Your Ref: 000014190
Our Ref: WA/72/12/ 21-11-2012
Please ask for:
Mrs S Leeson

Revisions to previous approval WA/66/11 for the proposed refurbishment works to the Holly Tree pub including 4 no. bed & breakfast rooms
The Holly Tree Public House The Street Walberton

TITLE
SITE PLAN AS PROPOSED
OPTION 2

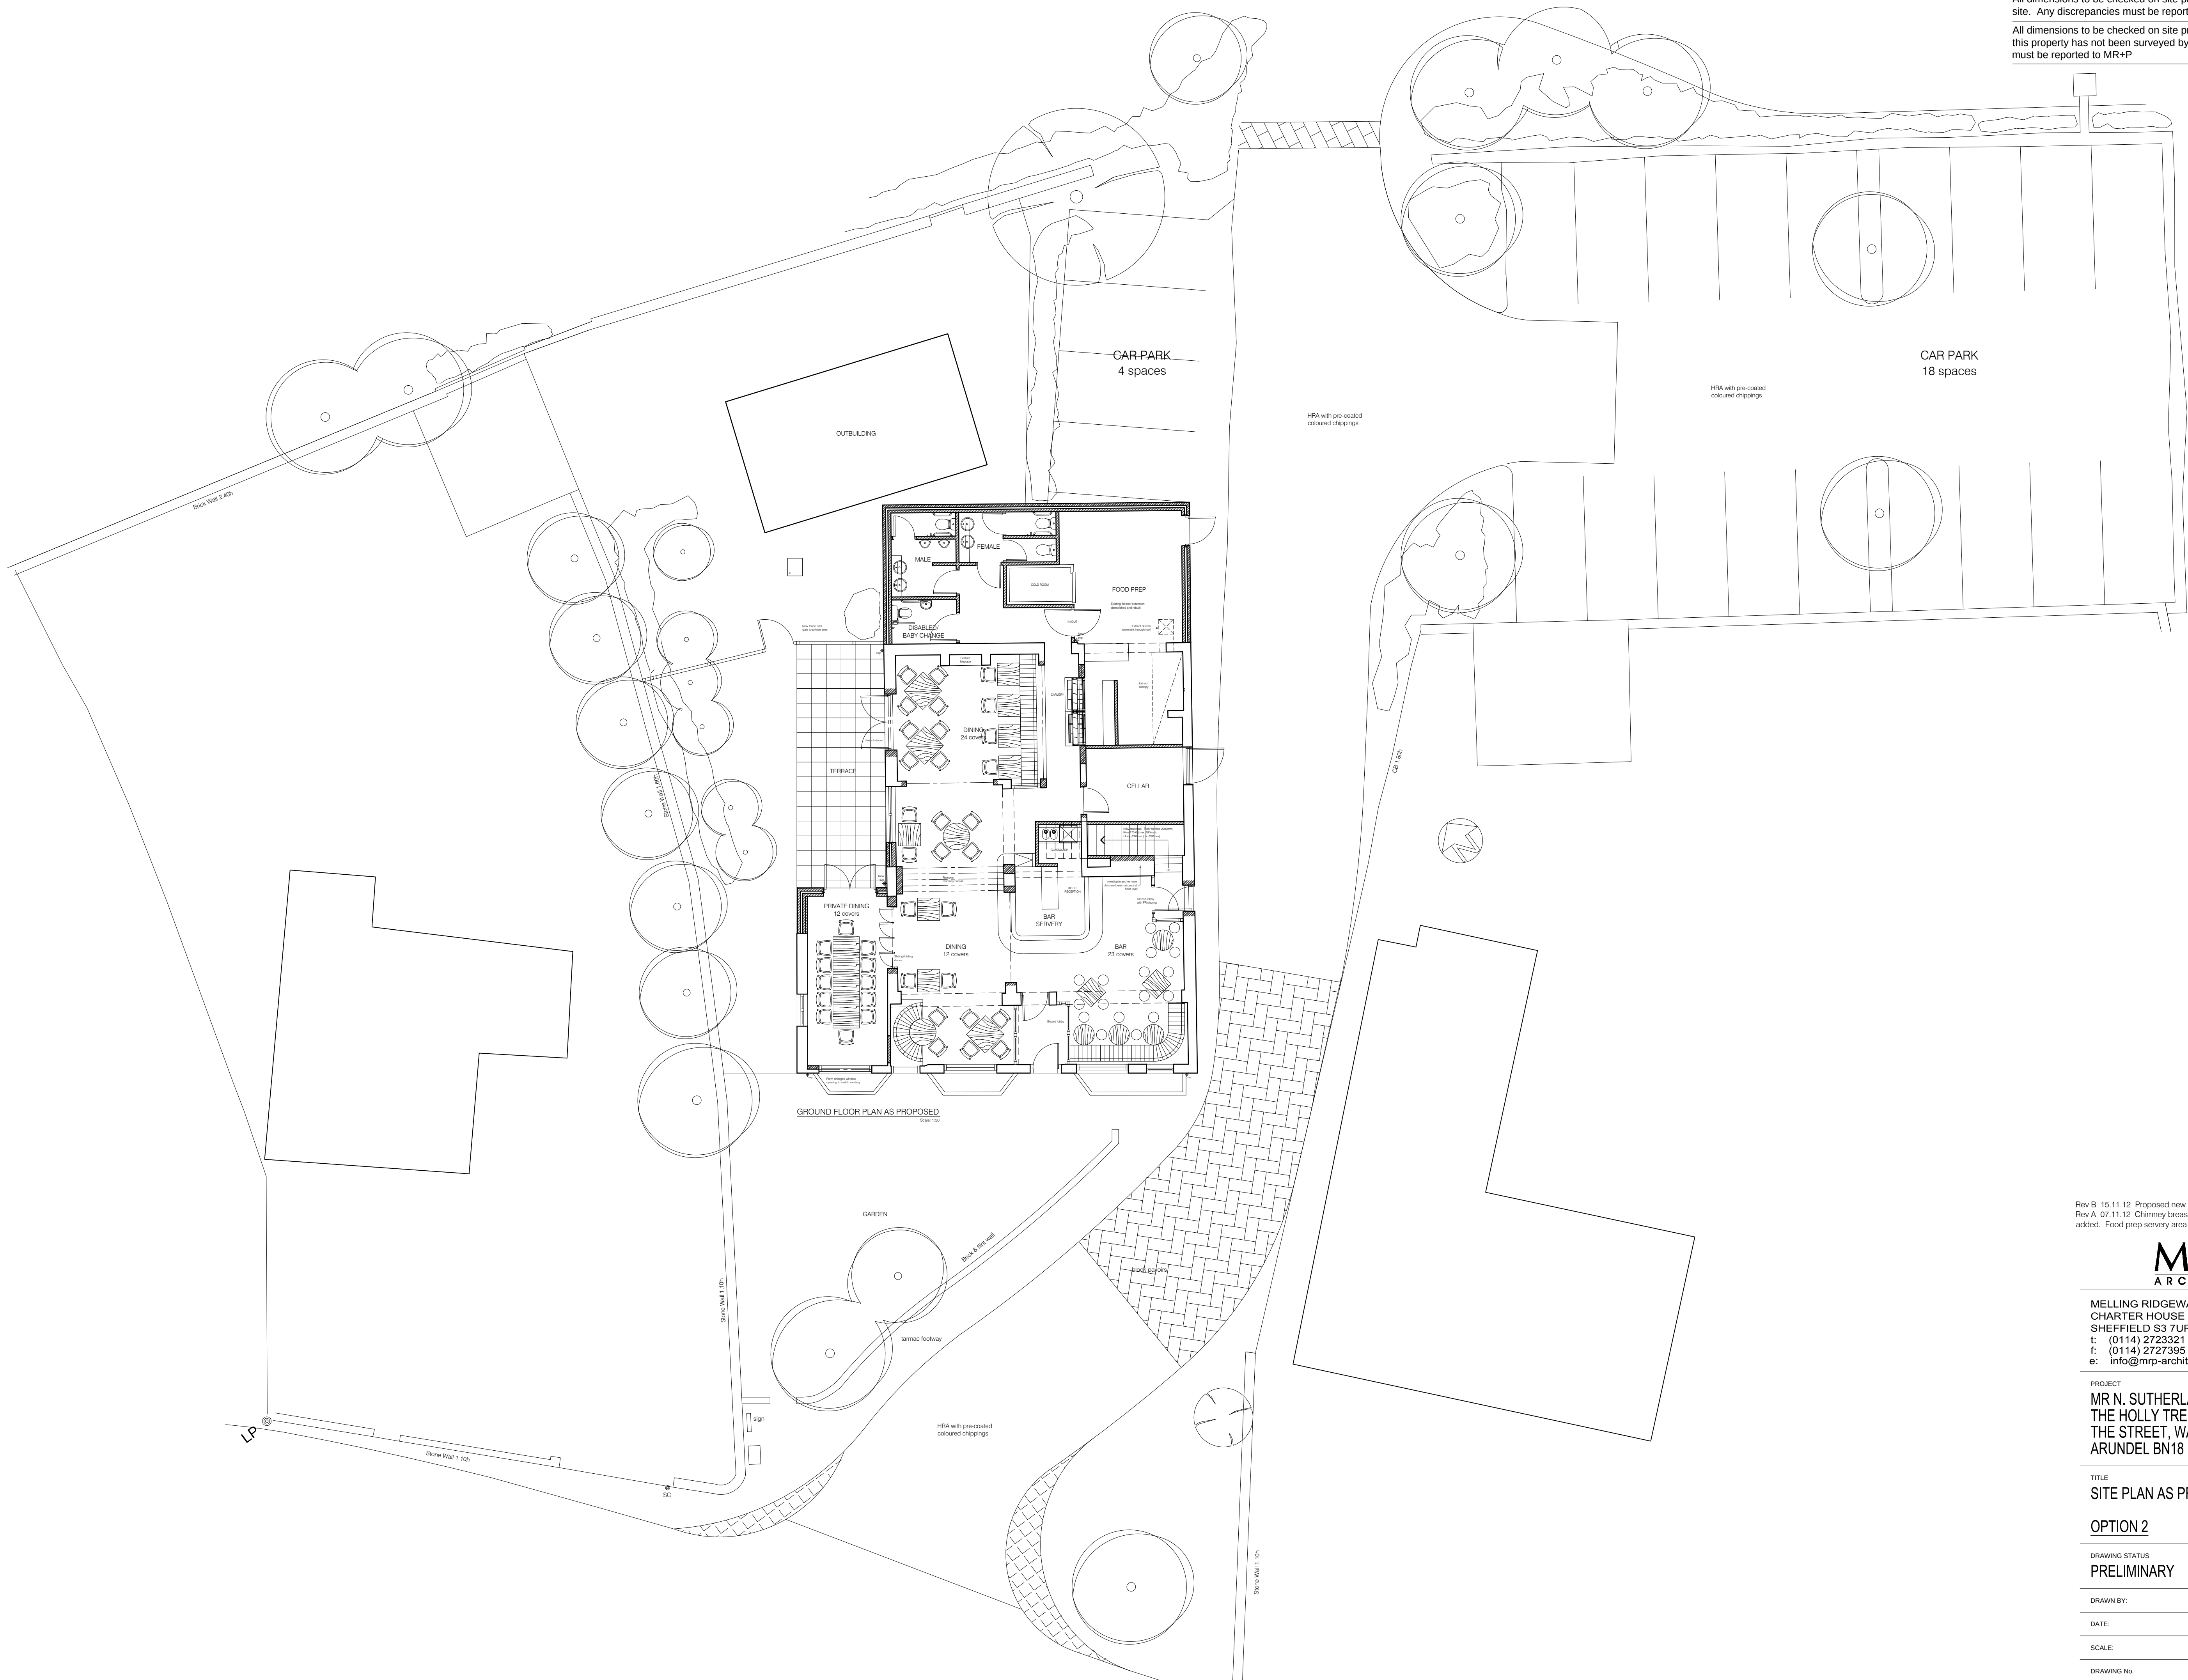
I object to this application on the grounds of loss of residential amenity caused by the applicant's plan to create a new outside eating, drinking and smoking area adjacent to our back garden. The addition of this space will affect our entire property both front and back in contrast to the restriction of the pub beer garden to the front of the property as was previously the case. We anticipate a significant loss of privacy and nuisance as a result of noise and the outside smoking area and are disappointed that the plans include no measures to ameliorate this.
